Engineers Comments Regarding Surface Water Drainage

Application Reference:	A/229/24/DOC	Reviewer Reference:	ADC/EXT05/GK
Planning Officer:	Amber Willard	Date of Review:	05/02/2025
Site Name:	Land North of Water Lane Angmering BN16 4EJ		
Application Description:	Approval of details reserved by condition imposed under reference A/88/24/S73 relating to condition number 3 - geotechnical arrangements for the bund; condition number 5 - drainage arrangements for the bund and condition number 6 - landscaping details for the bund.		
Assessment Number:	1 of 2

Condition 5

NORTHERN NOISE BUND
CATCHMENT AREA

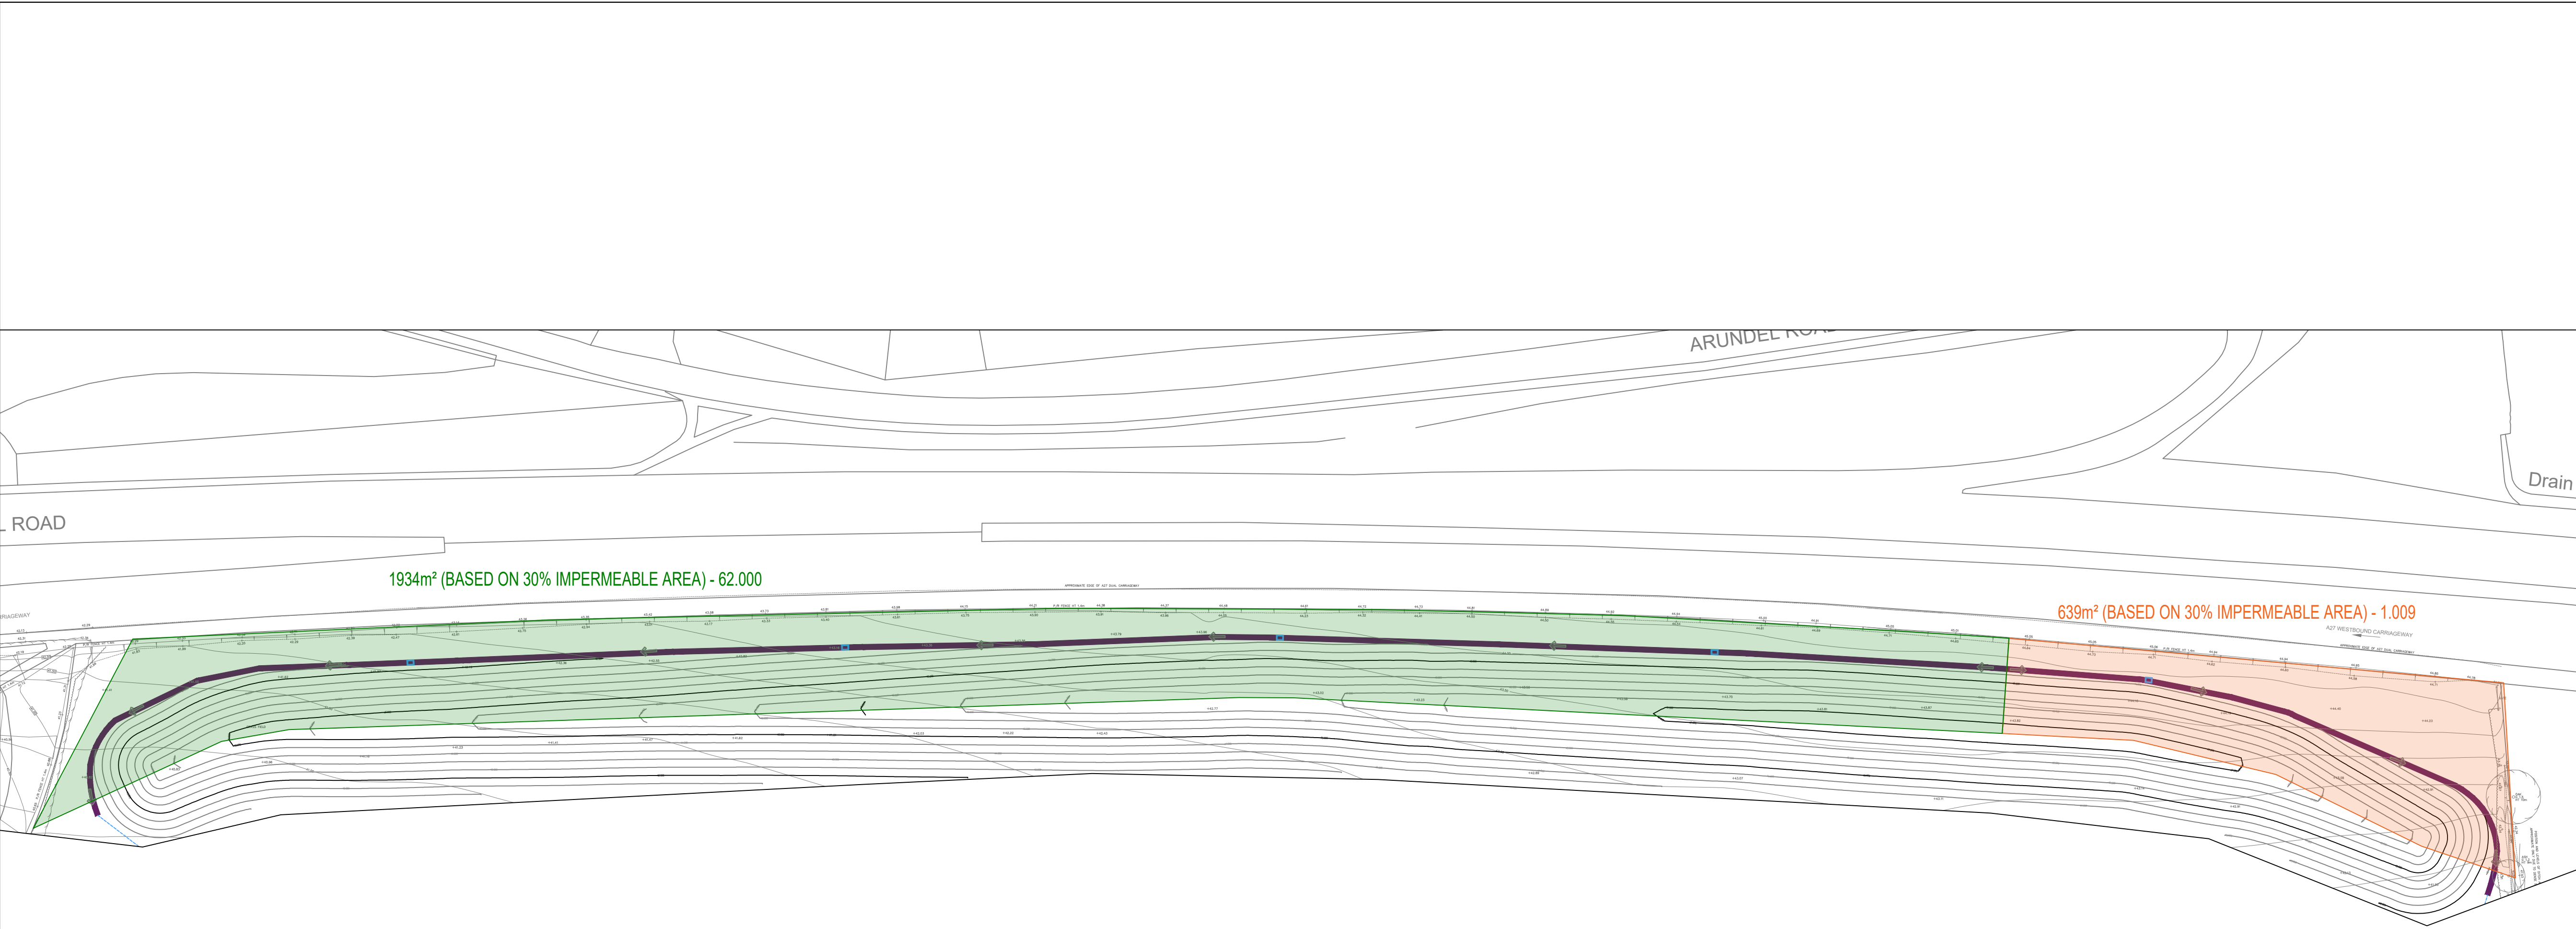
ADC Drainage Comments	Designer Response			
Date:	05/02/2025				
Condition Number: 5					
Comment Number					
1.	Please provide detailed construction details of the filter drain.				
2.	Please provide calculations confirming the capacity of the filter drain and also the capacity of the swale where the filter drain is discharging to. Additional flows from the development should be taken into account.				
3.	Please confirm how the surface water from the swale is discharging. If infiltration has been chosen as a method of discharge, please provide soakaway testing as per BRE365.				
4.	Please provide groundwater monitor results taken during the winter months September – March.
